13 May 2021

Our Reference: SYD18/01322/48

Departments Reference: SSD 9522

**SECTION 4.55 (2) MODIFICATION TO PROPOSED WAREHOUSE & LOGISTICS HUB
657-769 MAMRE ROAD - KEMPS CREEK - SSD 9522-MOD 1**

Figure 2: Subdivision Plan – Stage 1

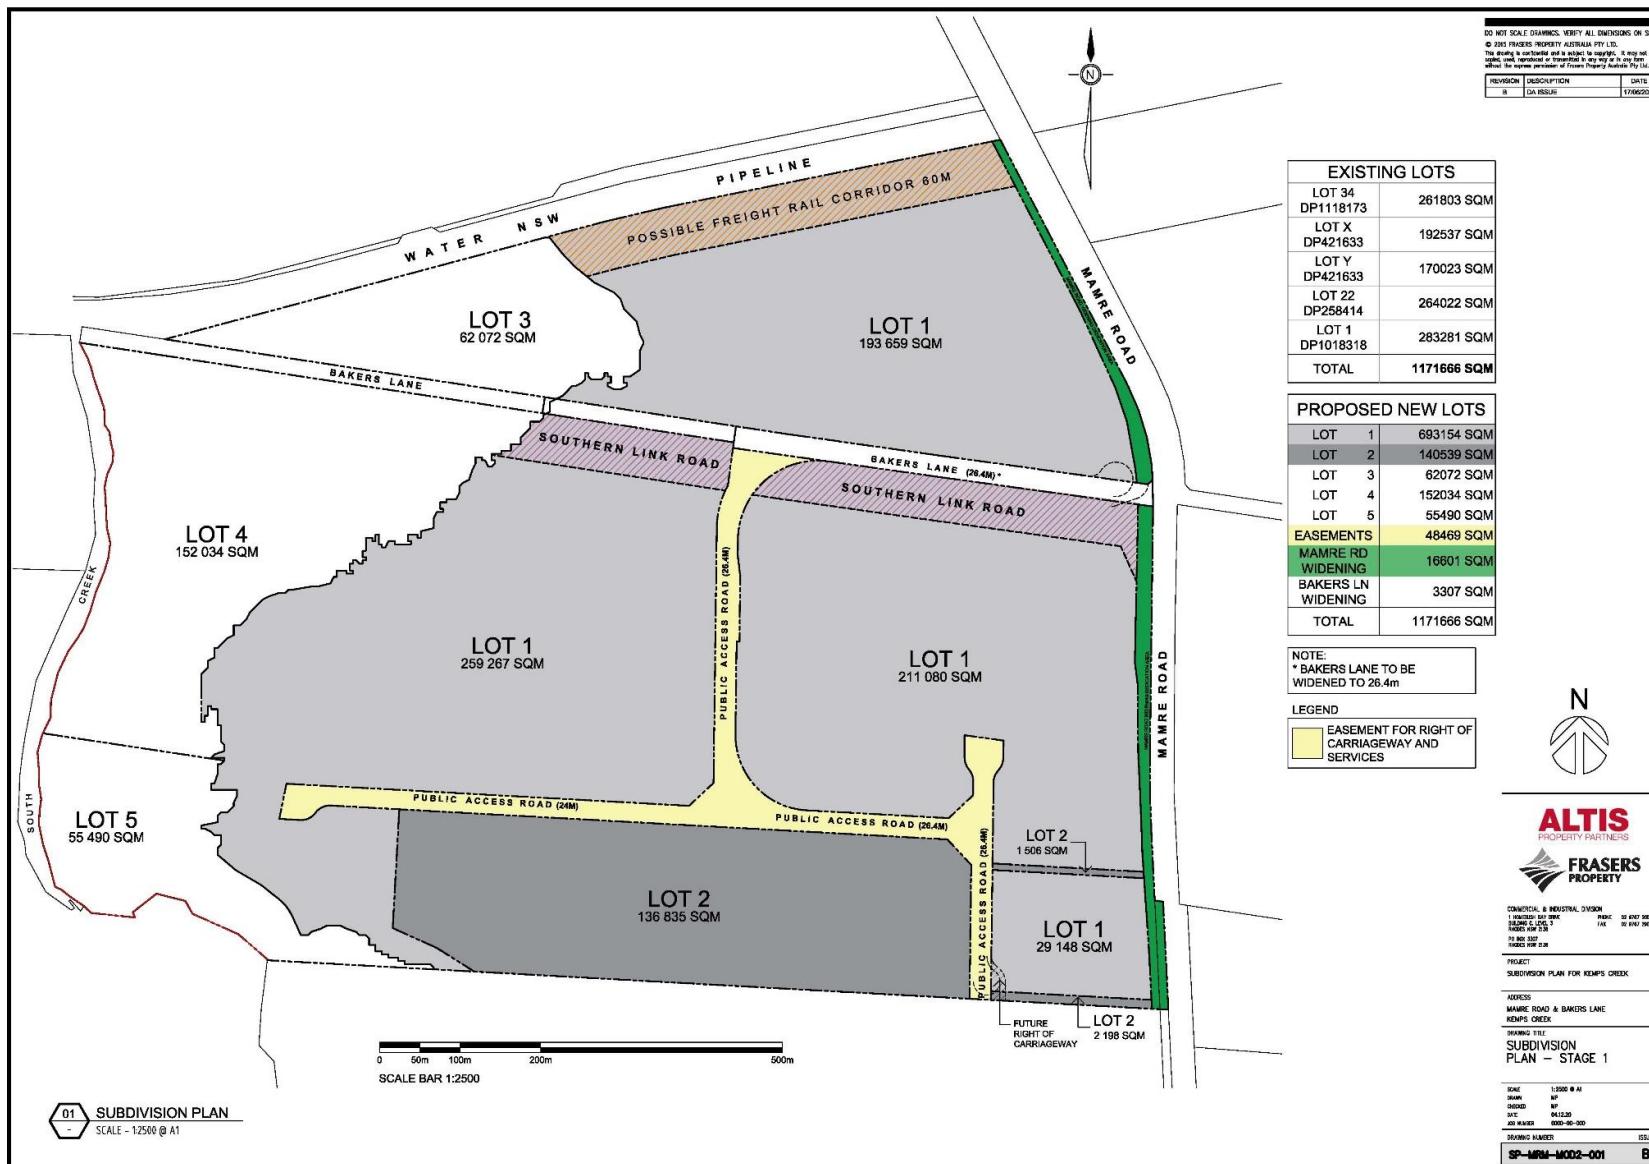
TfNSW notes that the modification includes an amendment to Lot 1, comprising an increase in Site Area from 680,972 m² to 684,083 m². TfNSW would not support any changes to Lot 1 until Condition B18 of the development consent has been adequately addressed and the required changes are supported by TfNSW.

In this regard TfNSW suggests that any modification to Lots 1-4 is removed from this Modification application until such time as condition B18 has been adequately addressed and the changes are supported by TfNSW.
